DECISION DELEGATED TO DEVELOPMENT MANAGER

Application No: H04-0514-19 **Applicant:** George Barnsdale & Sons Ltd

Proposal: Details of surface water disposal (Condition 3 of H04-0268-16)

Location: George Barnsdale And Sons Ltd 24 - 26 High Street Donington

Drawing title:
Site Plan

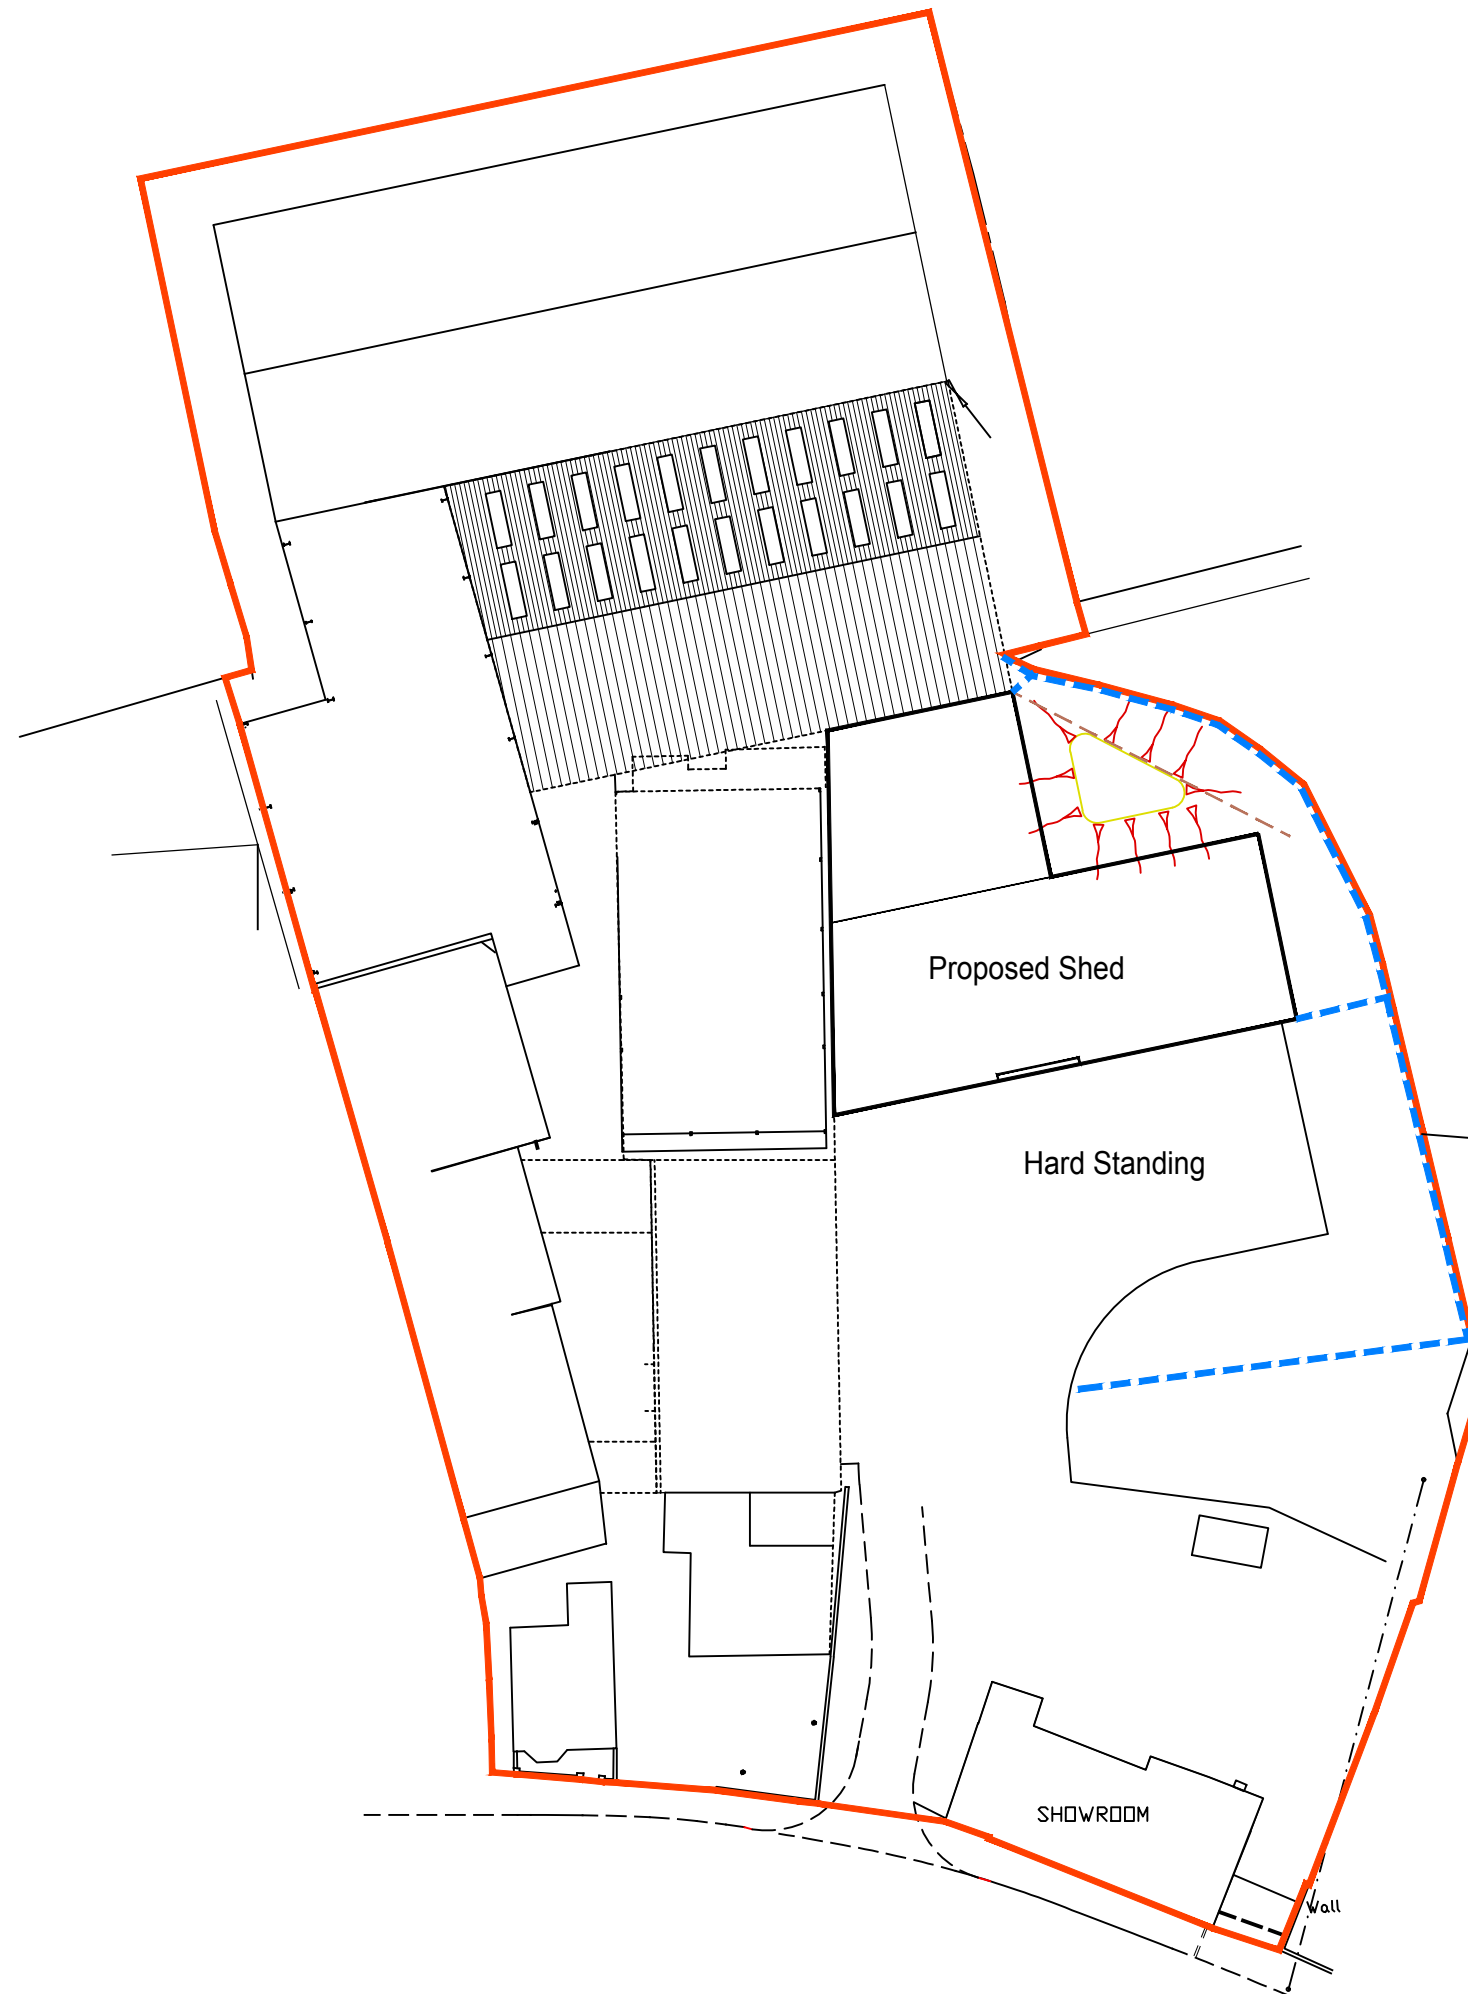
The submitted plan shows a perforated pipe running to a soakaway. The pipe runs on the boundary of the site with the adjacent school playing field. I have discussed this with Building Control who feel it is suitable.

The proposals are suitable and can be approved.
